**Transport
for NSW**

**Section 75W Modification Application (MP08_0241 MOD 5)
86-96 and 100 Mount Street, North Sydney**

TfNSW has reviewed the supporting documentation and comments are provided in relation to Railway Infrastructure Contribution, Active Transport and Construction Traffic Management at **TAB A** for consideration in the assessment of the application and in drafting of conditions.

design consultant
SOM
Skidmore, Owings & Merrill LLP
274 South Michigan Avenue, Suite 1000
Chicago, Illinois 60604

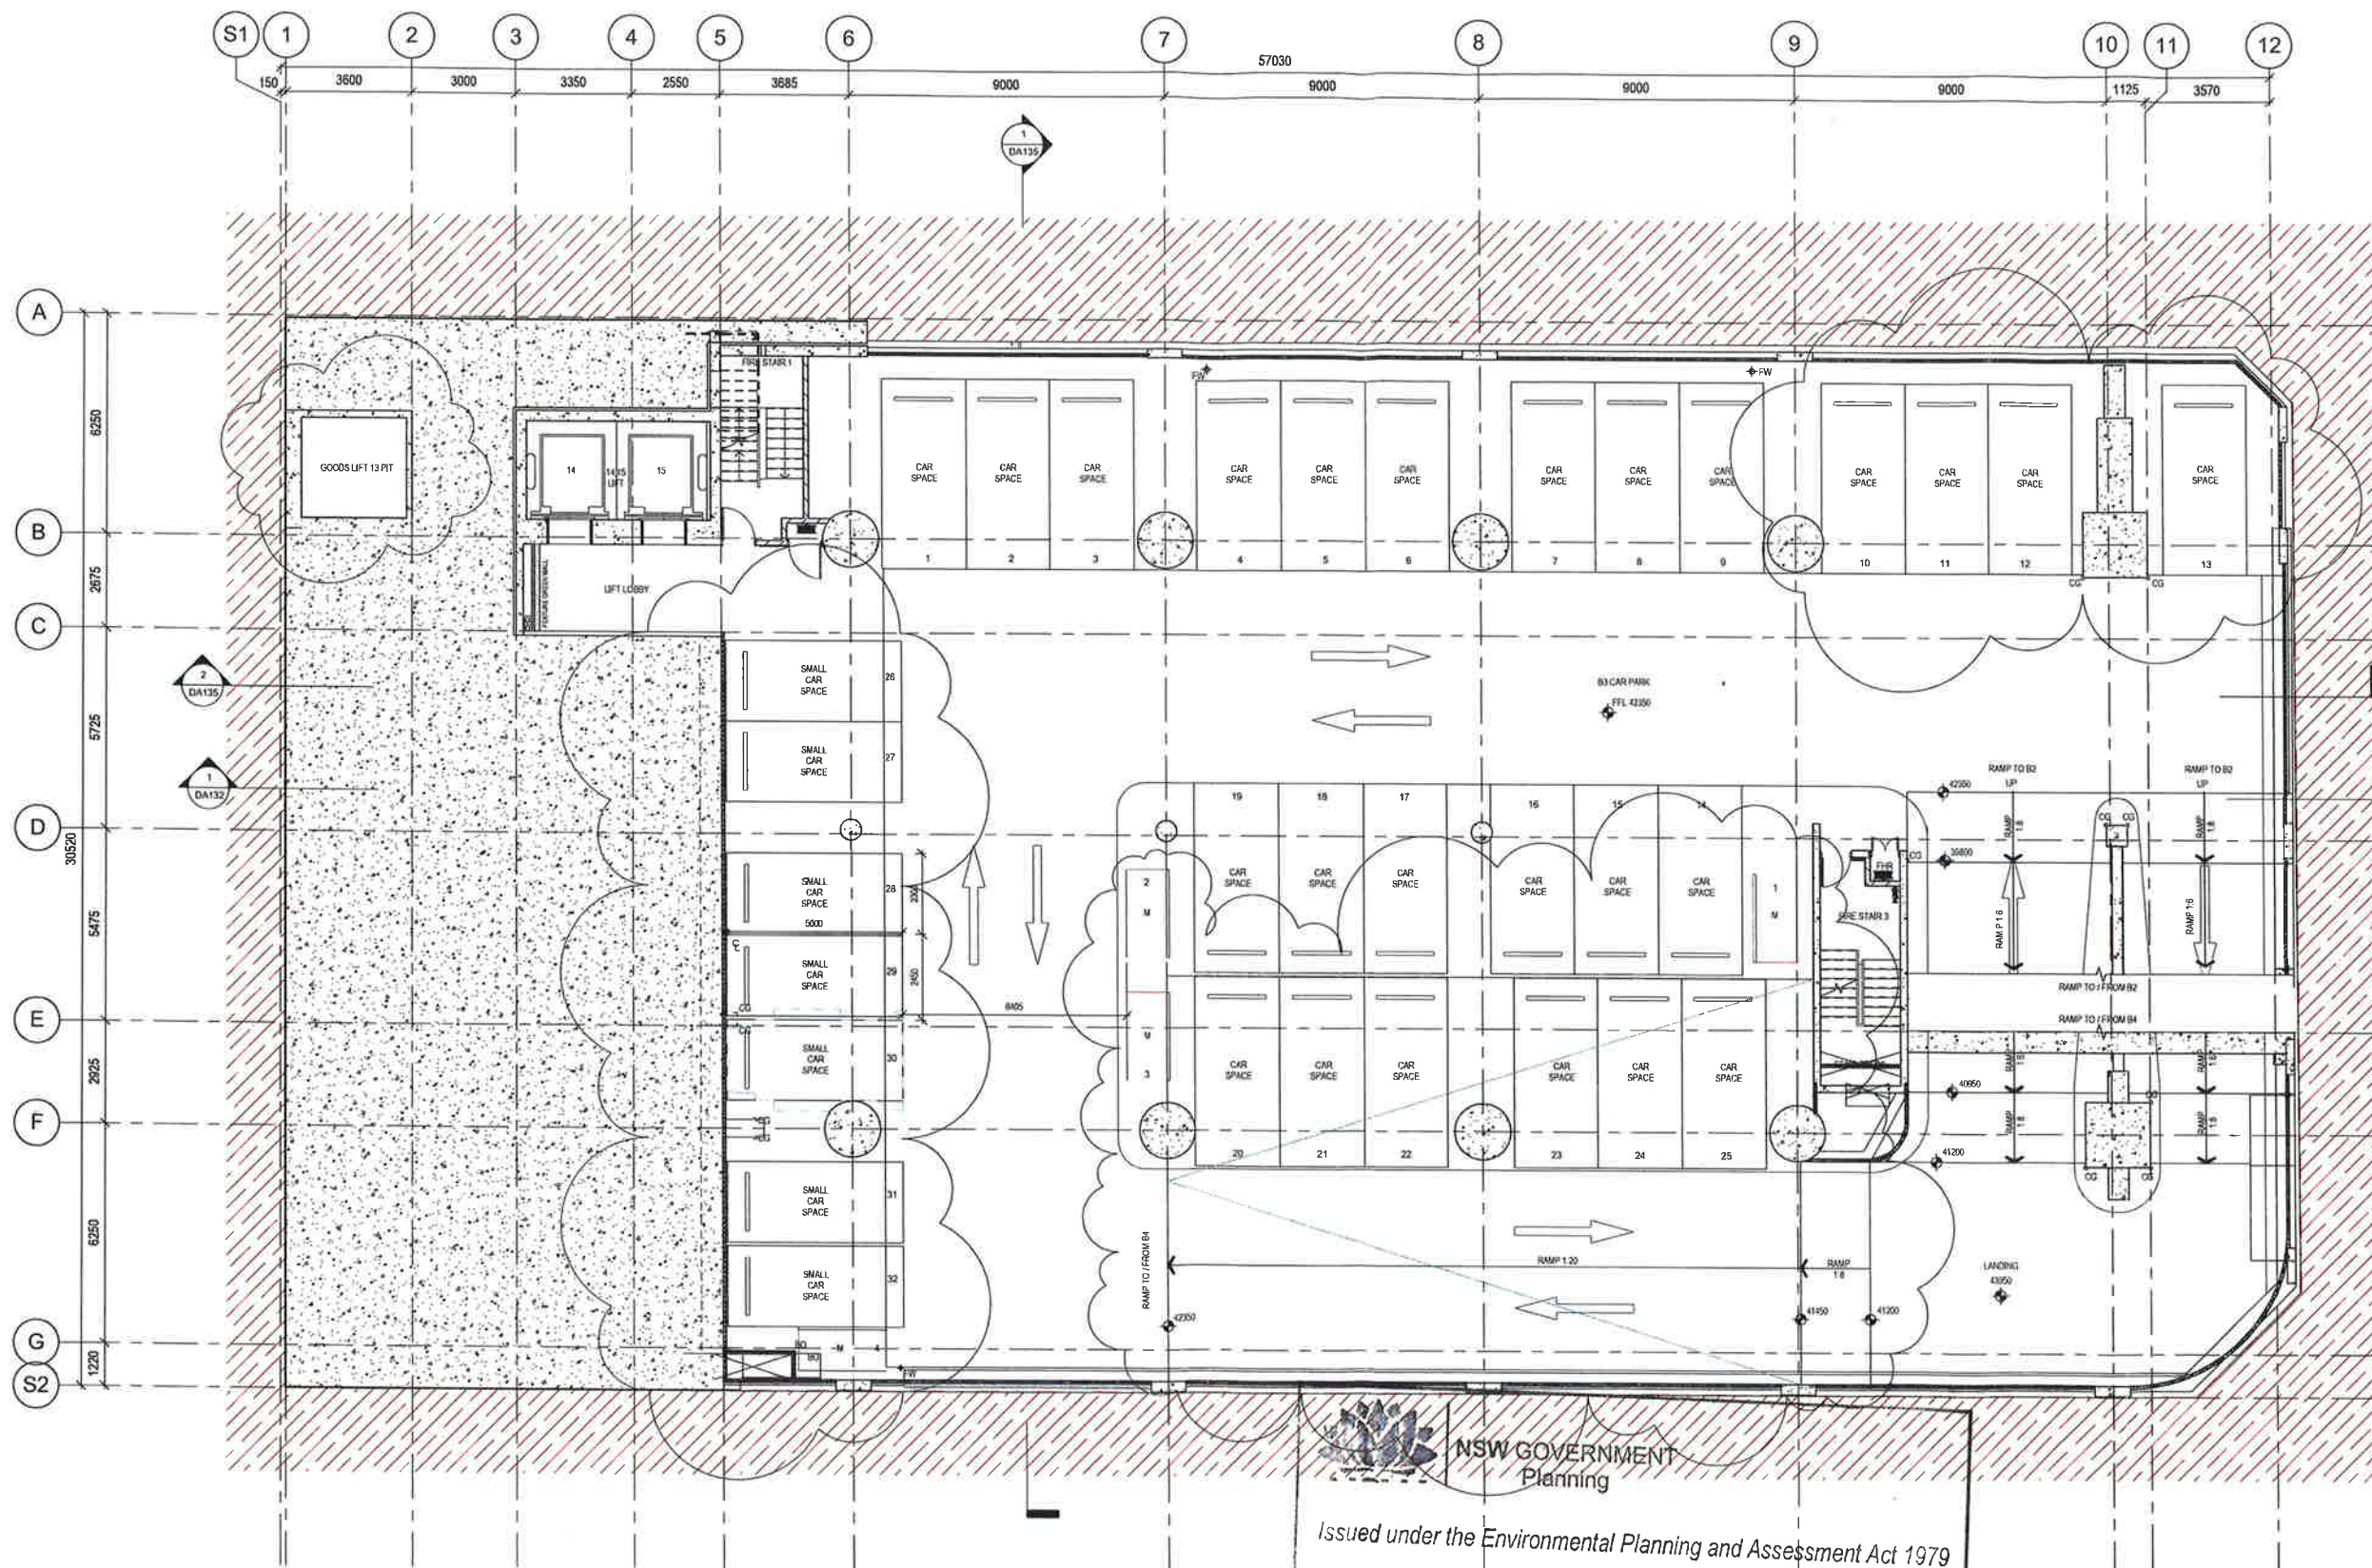
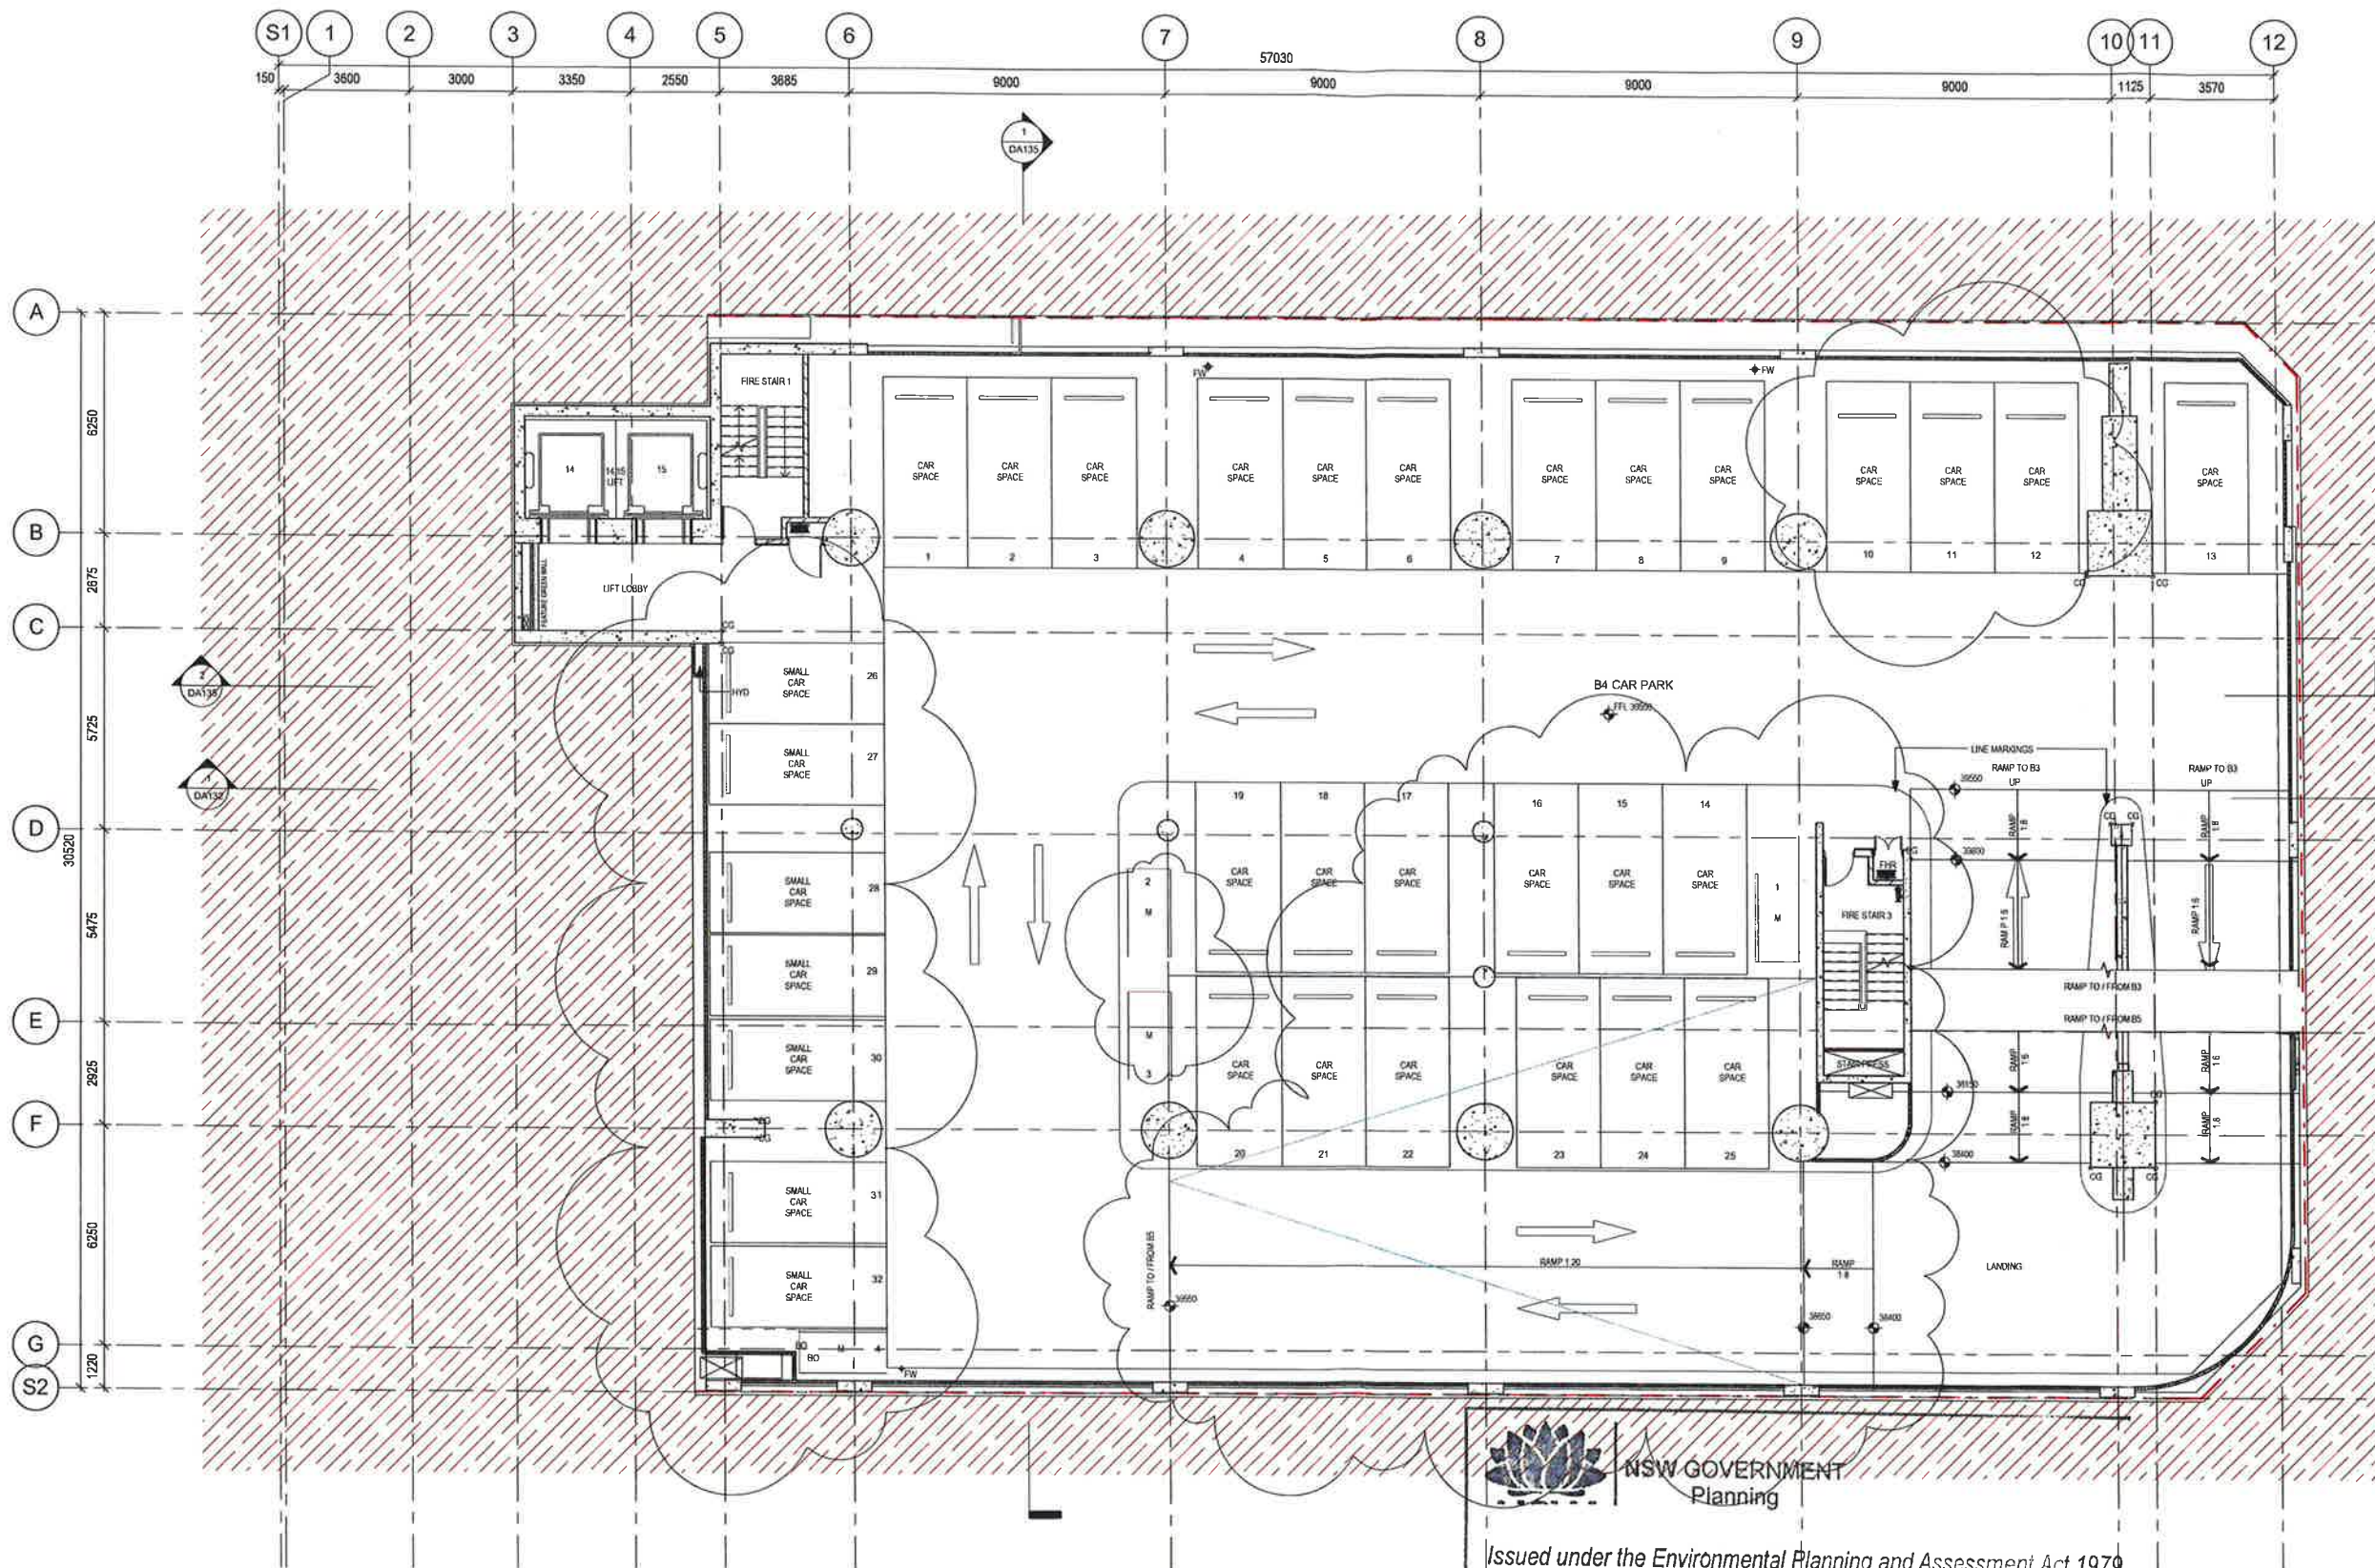
The proposal results in a loss of 96 bicycle parking spaces. Bicycle parking should be provided in accordance with North Sydney DCP requirements.
